# CITY OF ALBUQUERQUE

**Re: Garfield Apartments, 501 Girard Blvd SE**  
**Certificate of Occupancy – Transportation Development**  
**Engineer's Stamp dated 09-10-12 (K16-D079)**  
**Certification dated 07-26-13**

| CITY OF ALBUQUERQUE<br>PLANNING DEPARTMENT<br>ENGINEERING DESIGN REVIEW / CONSTRUCTION |                              |             |             |
|----------------------------------------------------------------------------------------|------------------------------|-------------|-------------|
| GARFIELD APARTMENTS - PUBLIC ALLEY IMPROVEMENTS<br>PLAN & PROFILE                      |                              |             |             |

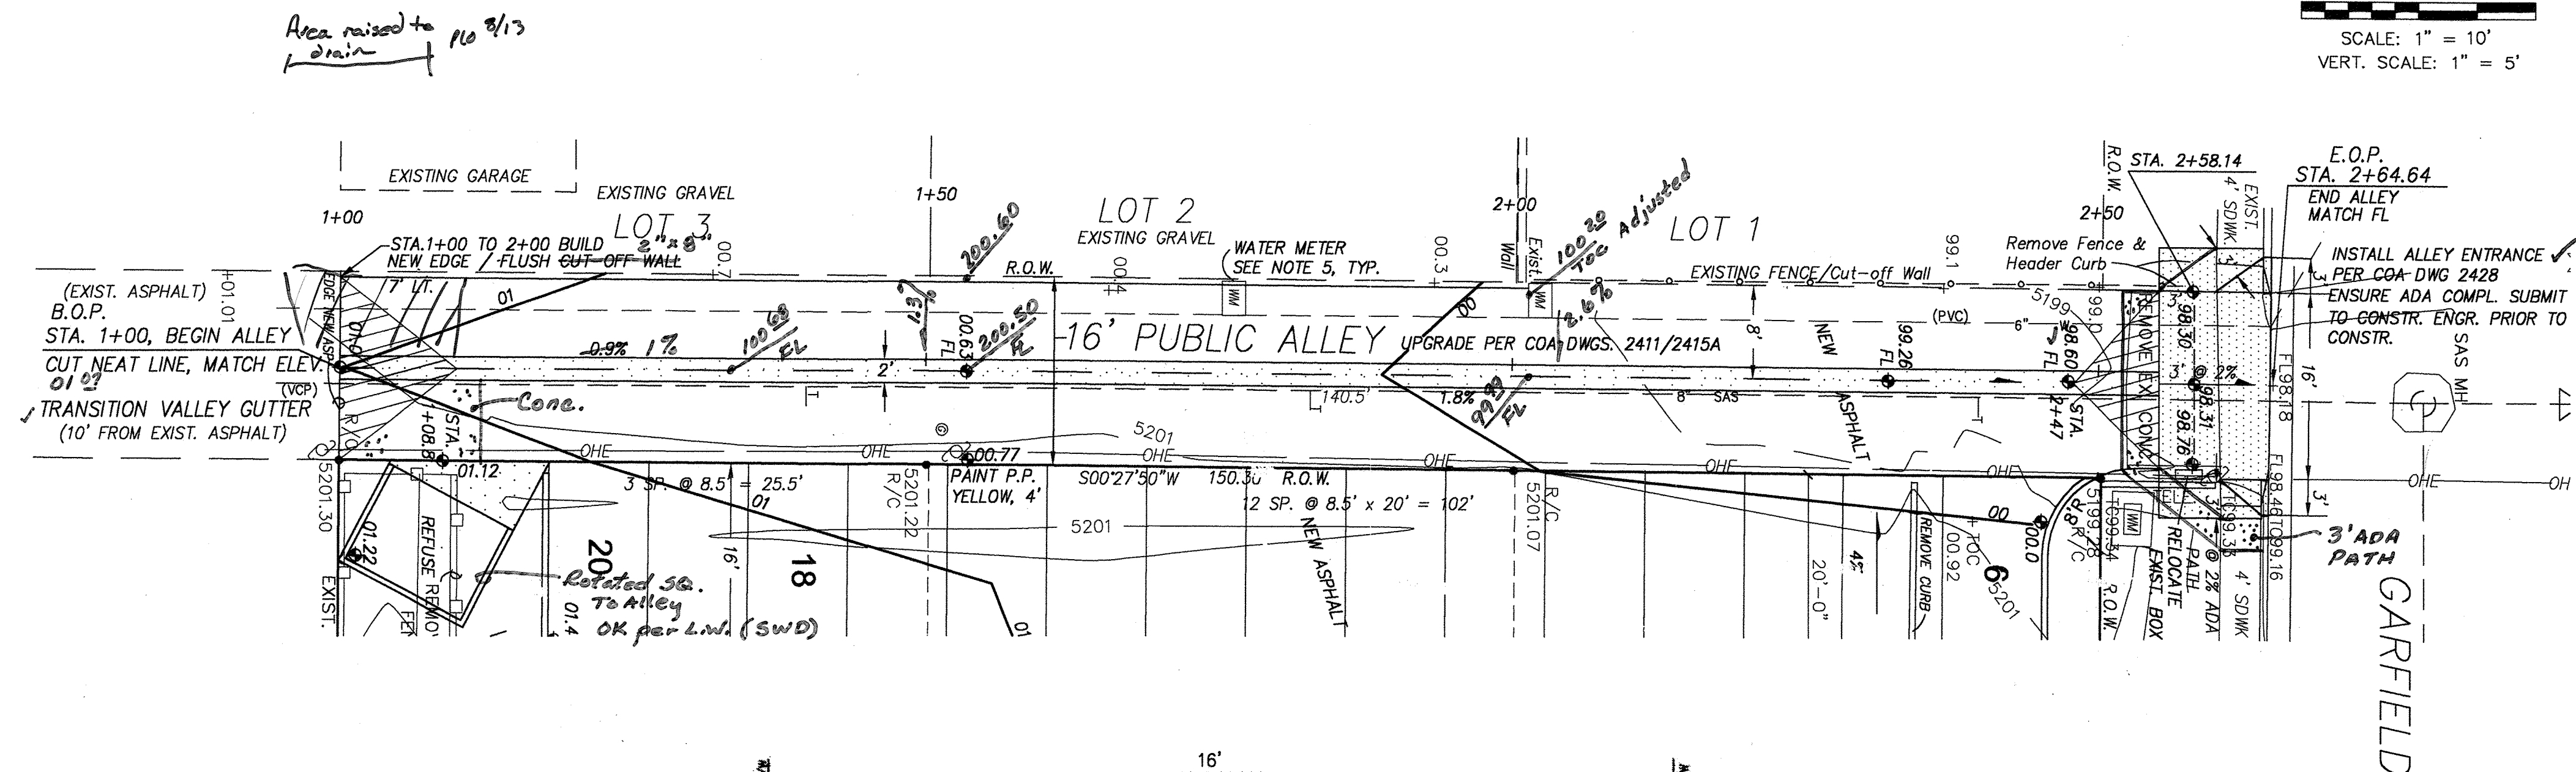
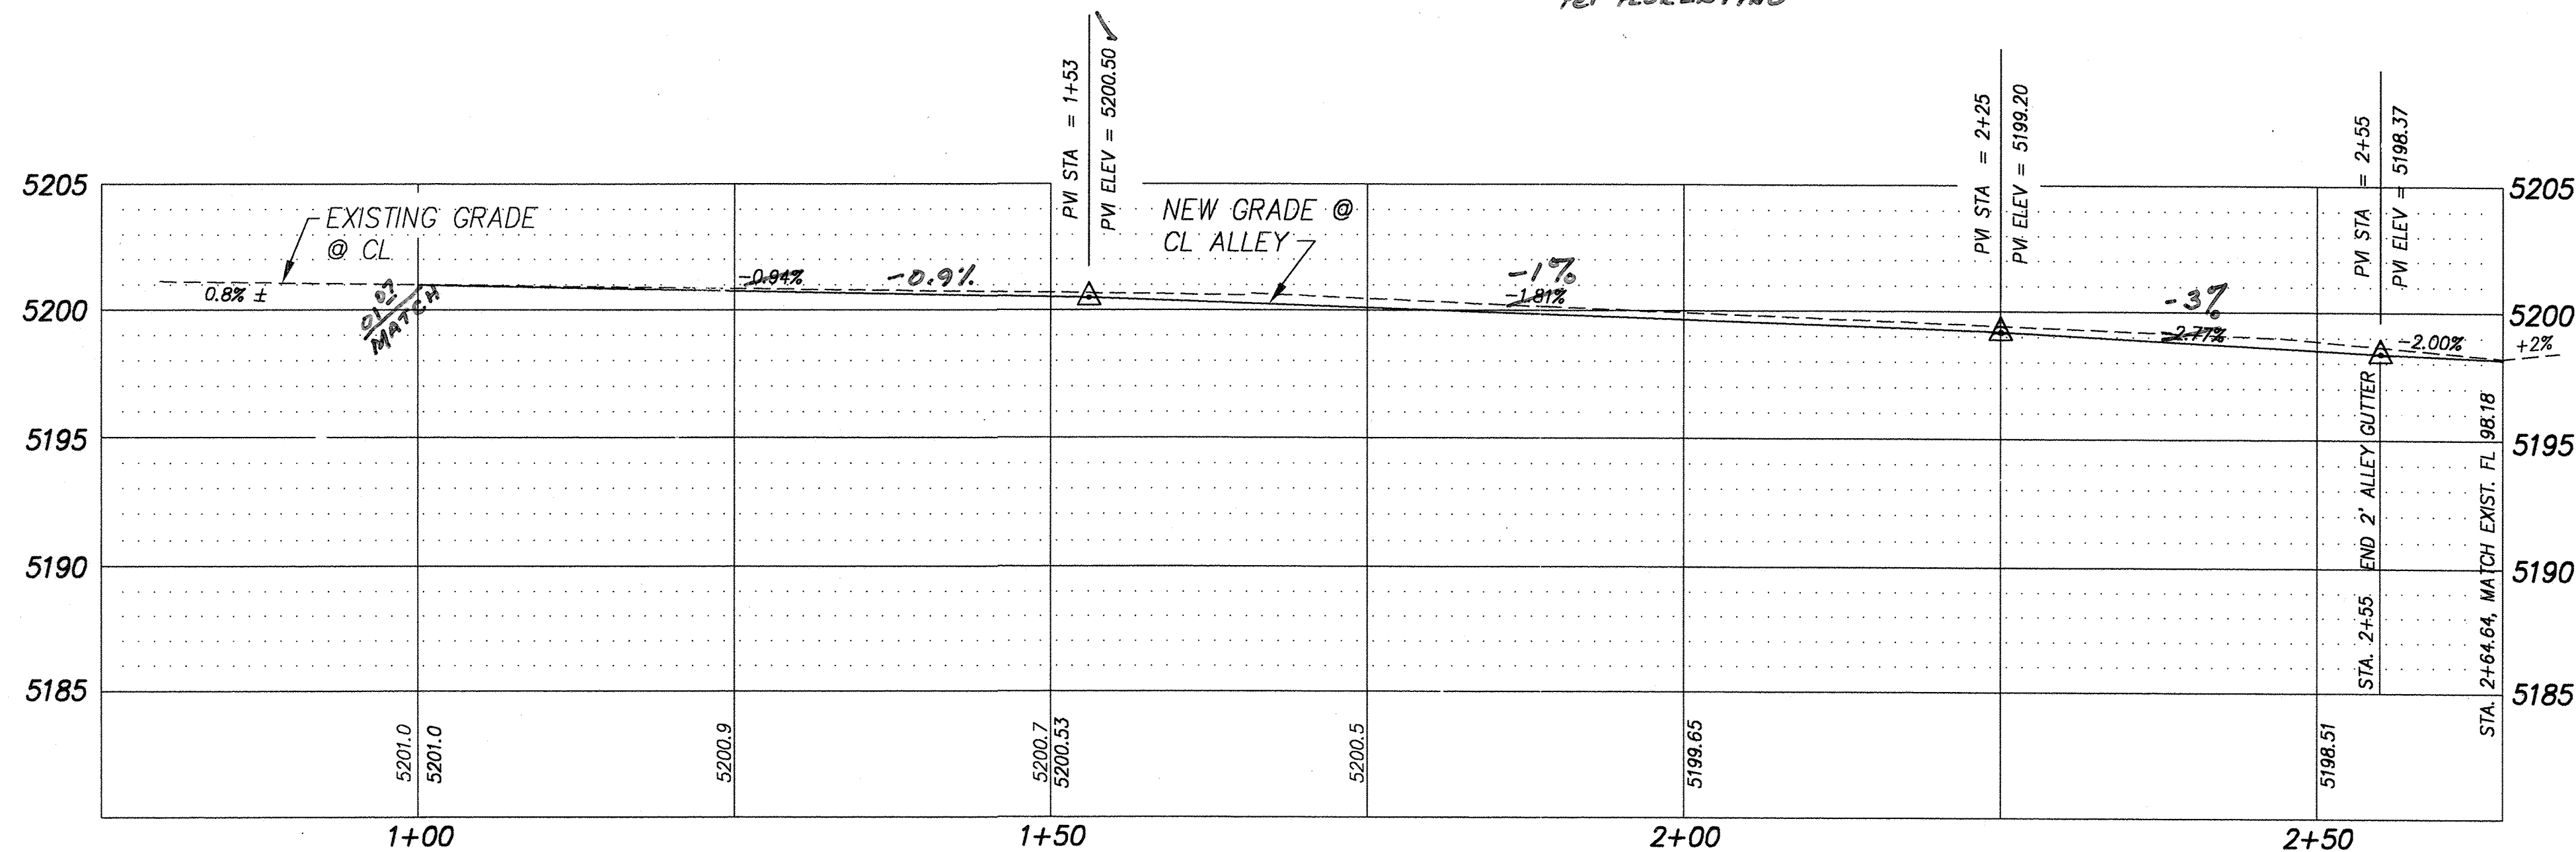
- The work order for the alleyway and parking stall improvements (CPN 644283) must be completed and closed out.
